Application no: H11-0526-10

Description: Two-storey extension to dwelling

Location: Evergreen
Jarvis Gate
Sutton St James
Spalding Lincs

ACKNOWLEDGEMENT OF AMENDMENT

Drawing Number:
10/250/PA/002

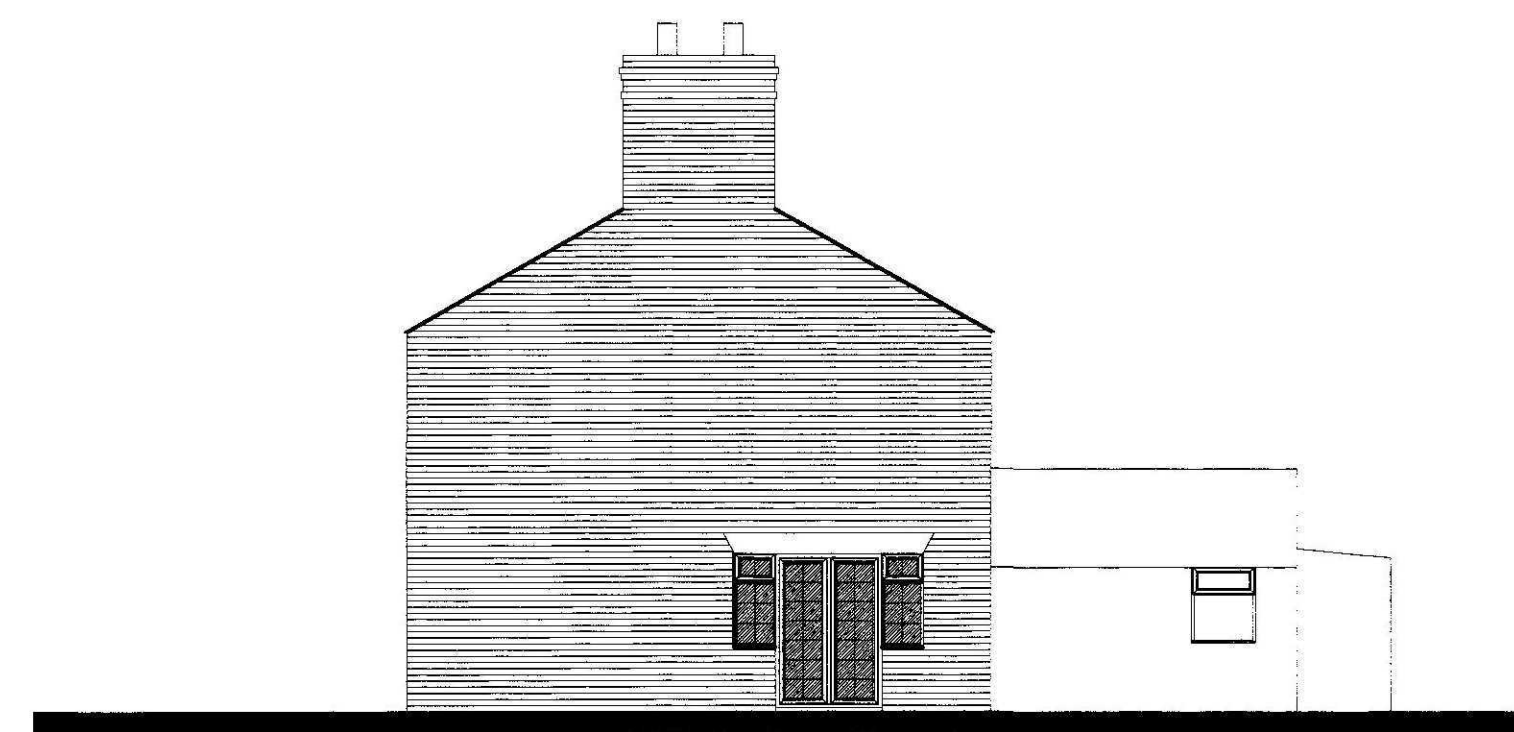
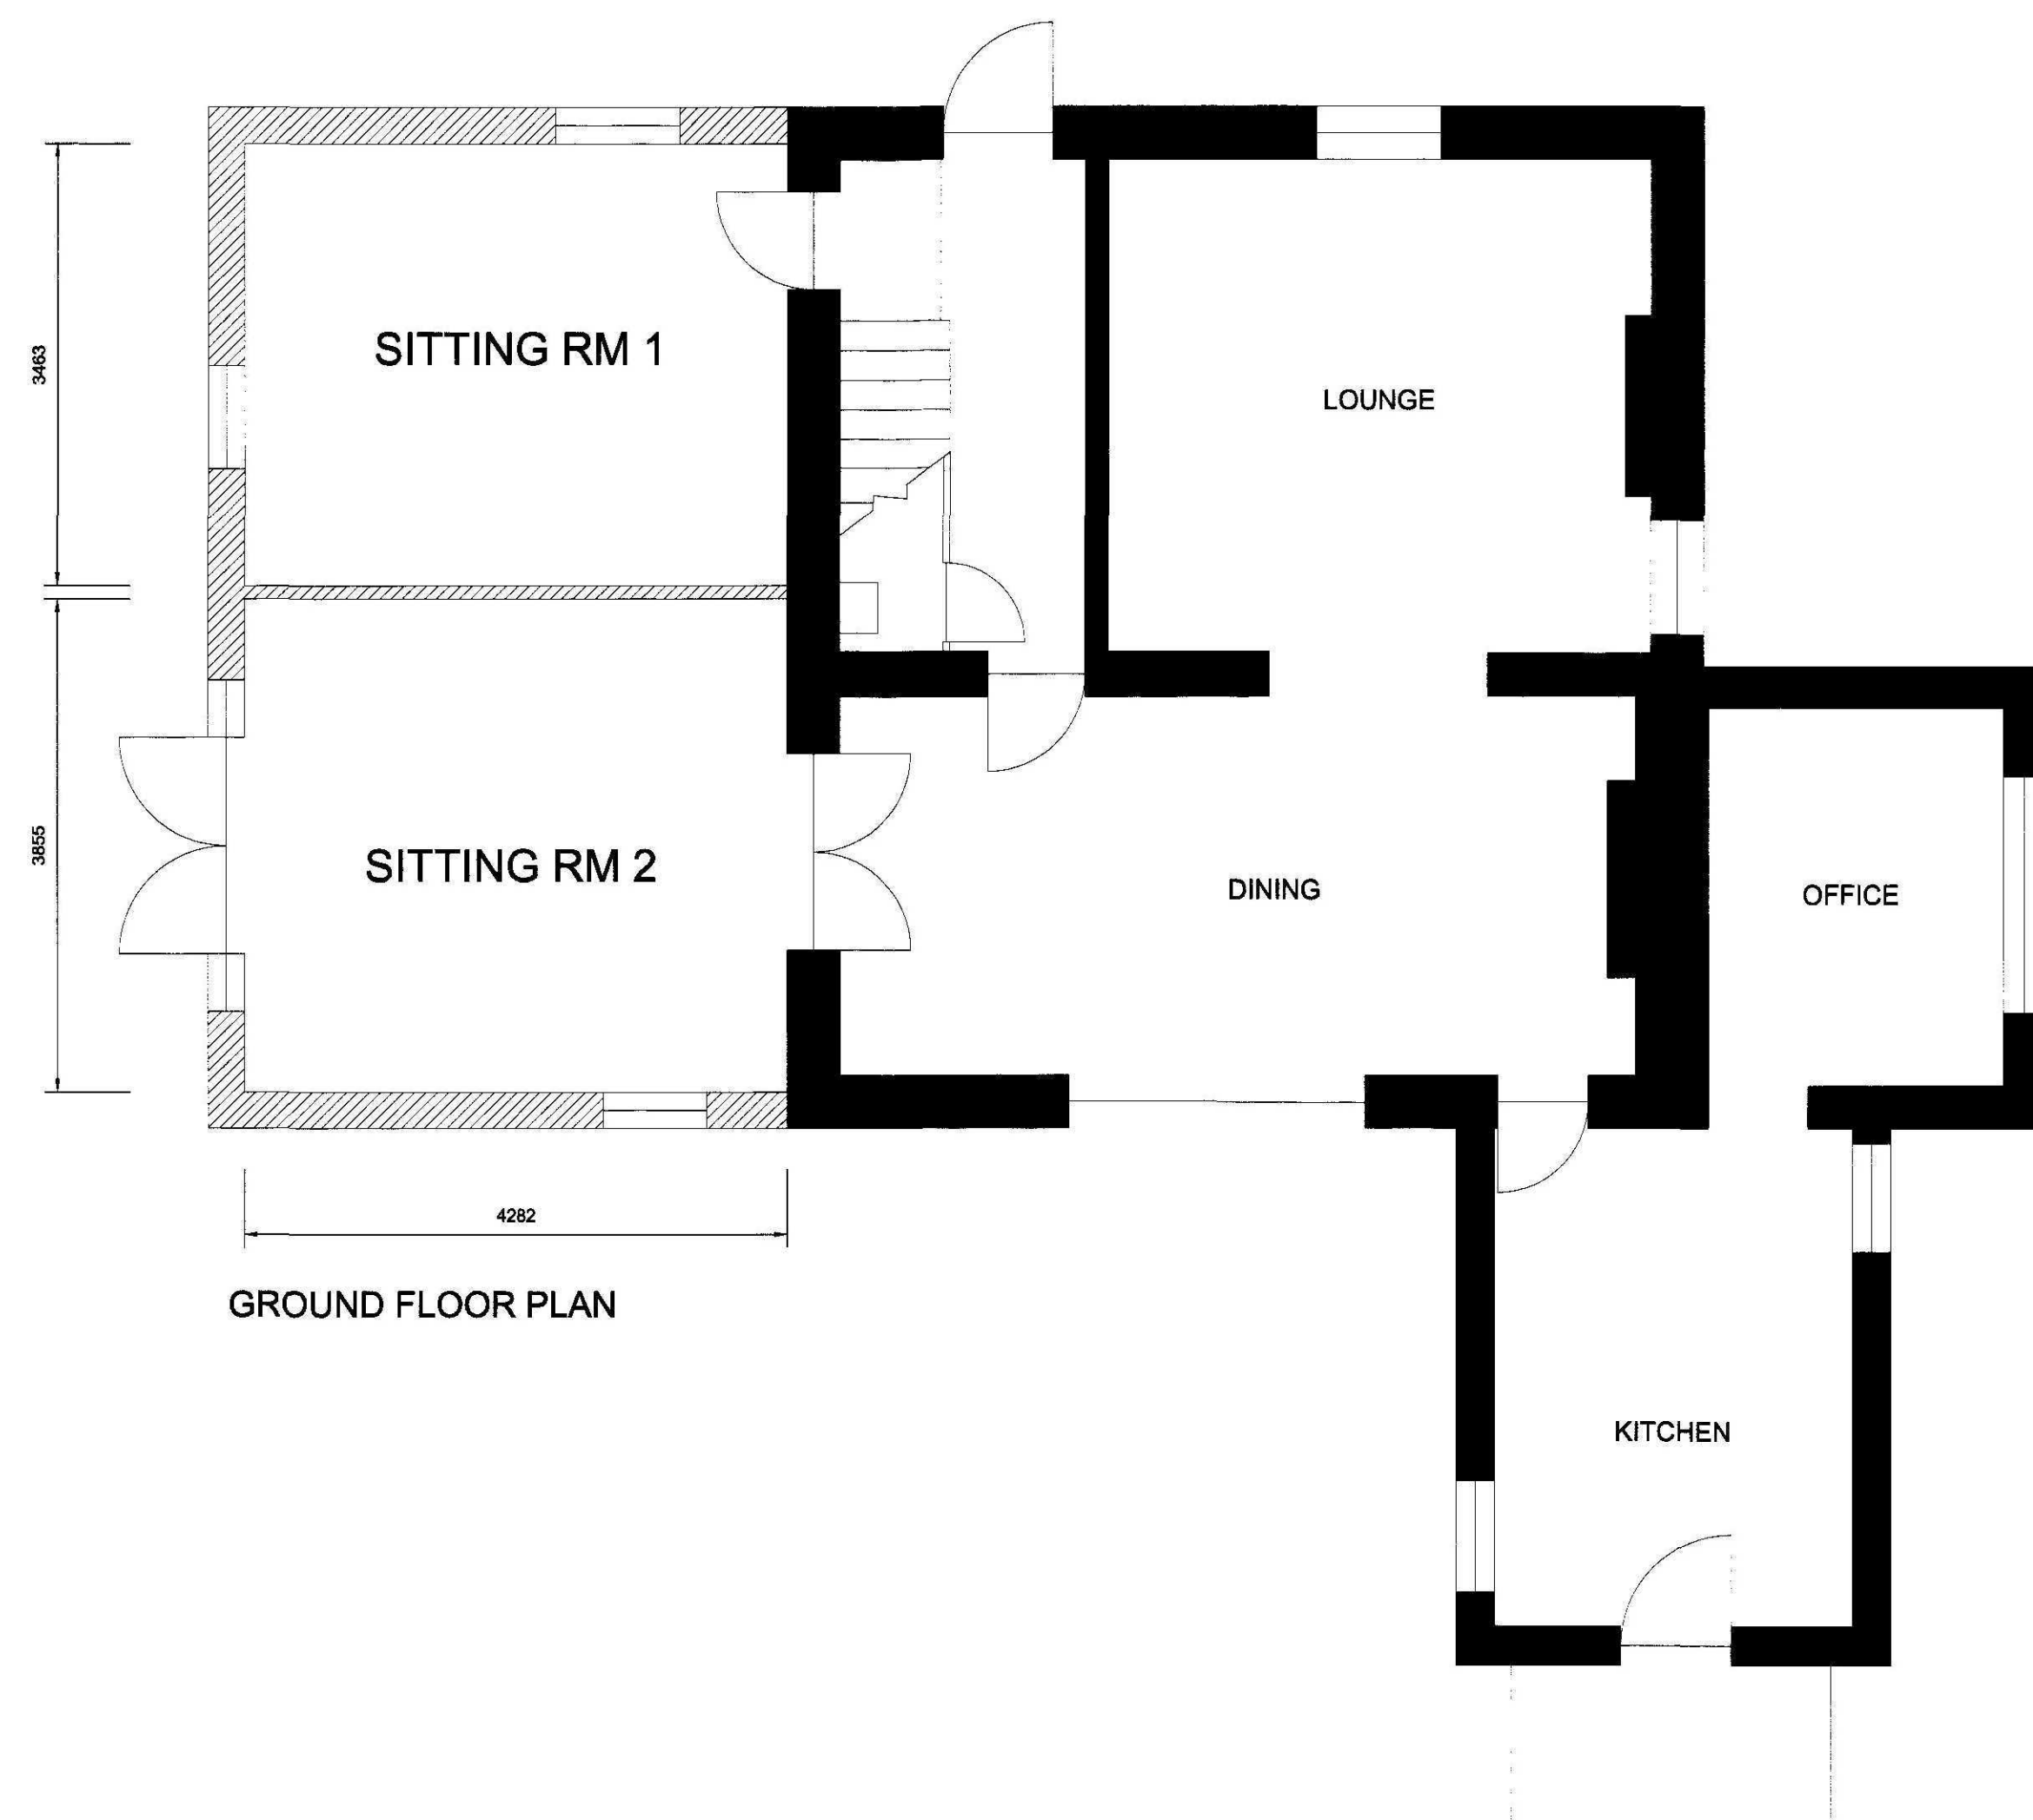
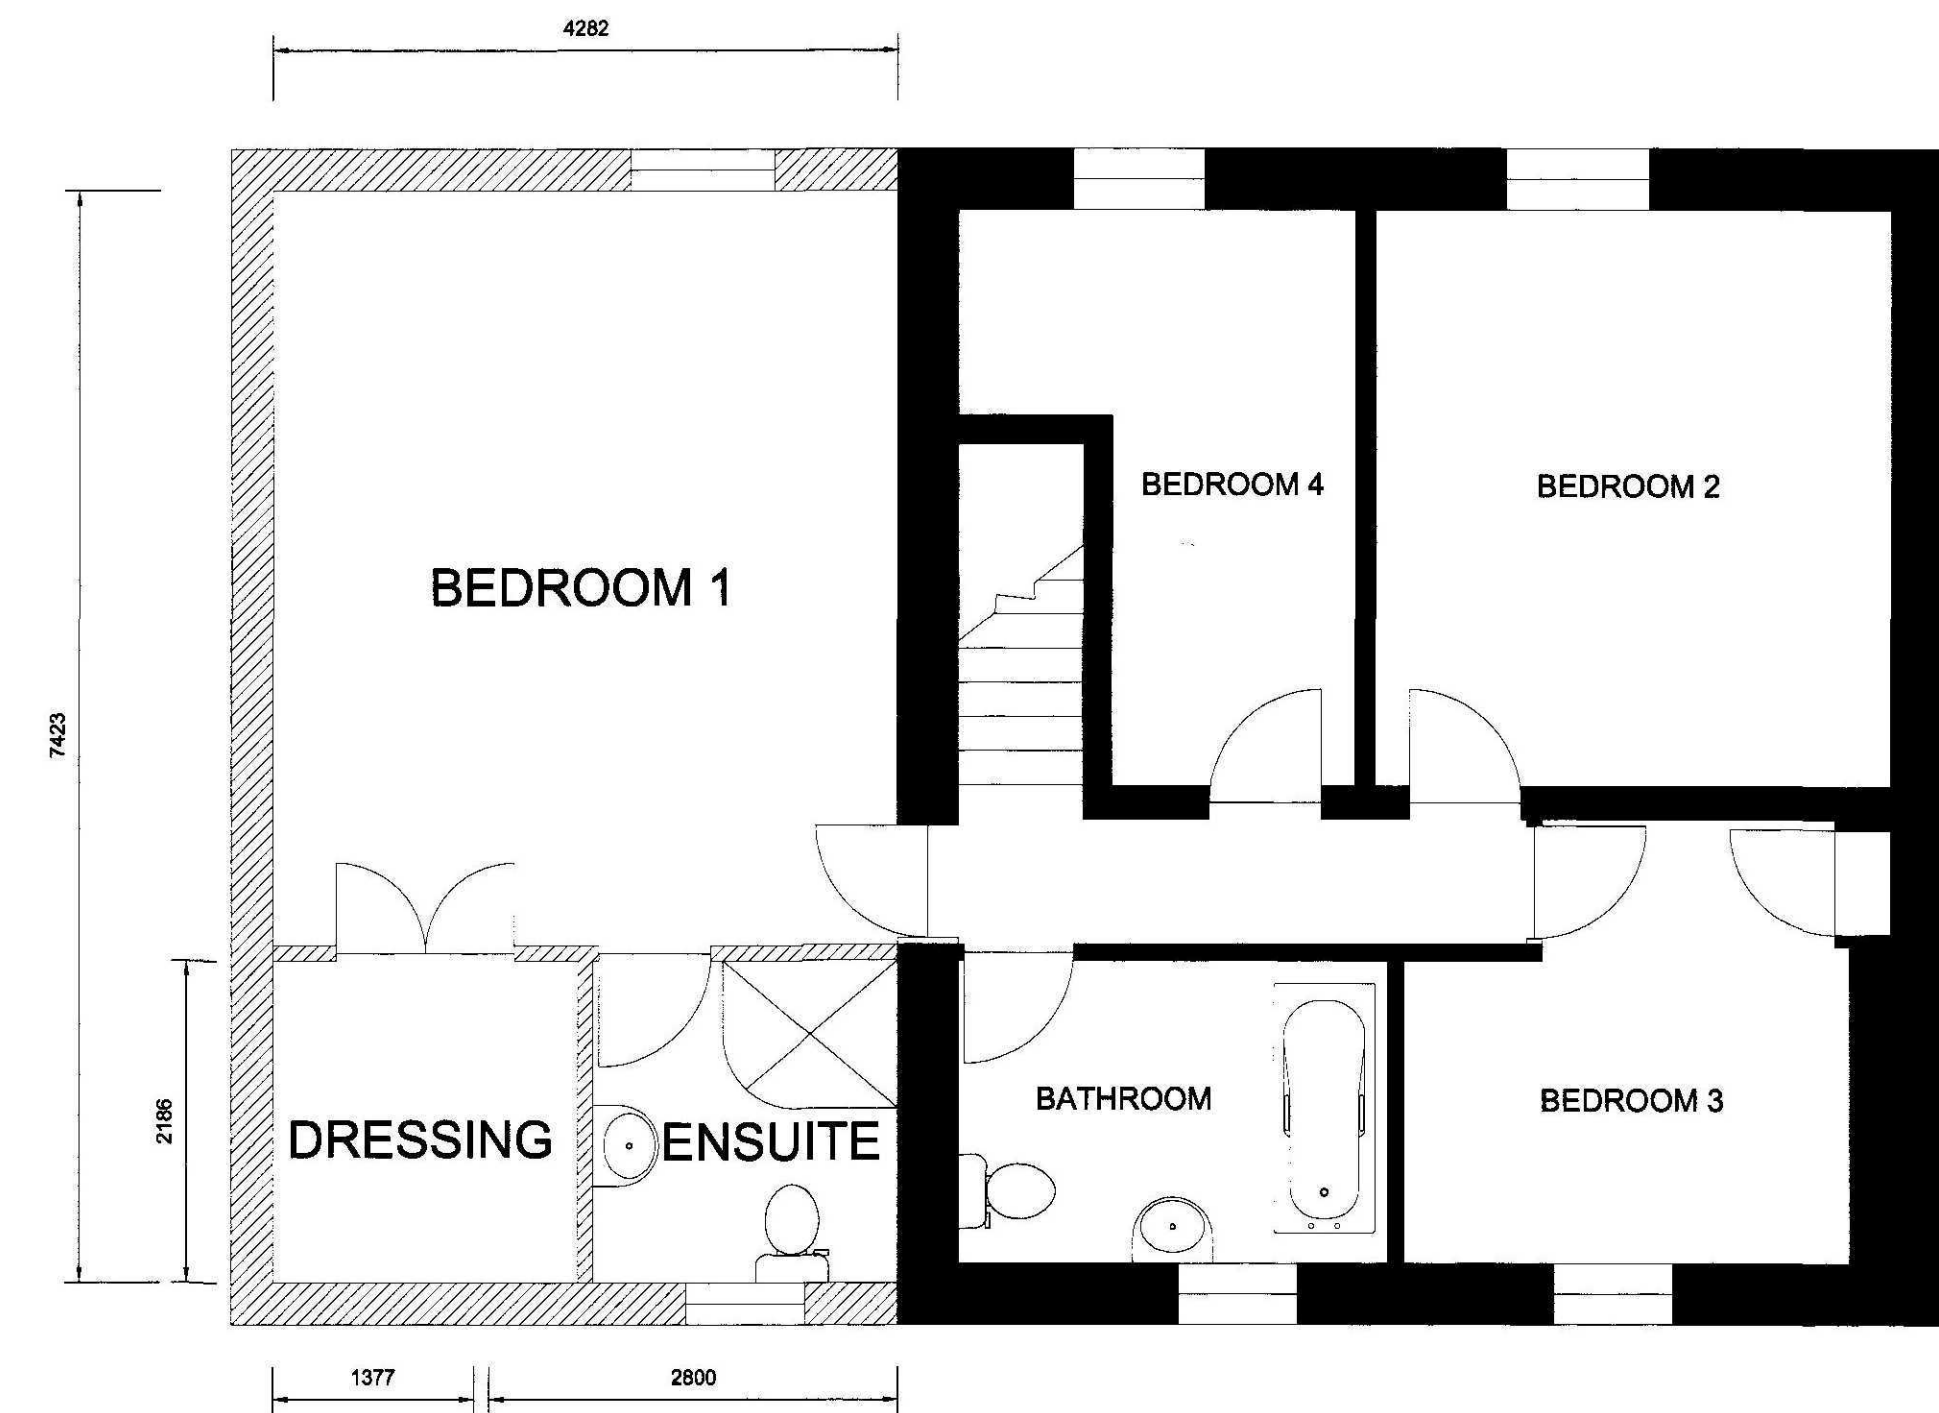
Amendment: Omit single-storey extension (dwg. no. 10/250/PA/002.B)

FULL DESCRIPTION OF DEVELOPMENT OF CURRENT APPLICATION THAT THIS AMENDMENT RELATES TO	TWO-STORY AND SINGLE-STORY EXTENSIONS	
State details of amendments proposed. (Give a full detailed list of the changes, and also mark these clearly on the accompanying plans. Only the changes listed here will be considered)	OMIT SINGLE-STORY EXTENSION	
State drawing numbers of the current submission	10/250/PA/002 B.	
Has this amendment been requested by the Council? (If so, state Officer dealing with the application)	YES/NO	
Describe any part of the original development which is excluded by virtue of the amendment, and state any alteration to plot numbers		
Has a similar amendment been submitted under Building Regulations? (If so, state Building Control Surveyor dealing with application)	YES/NO
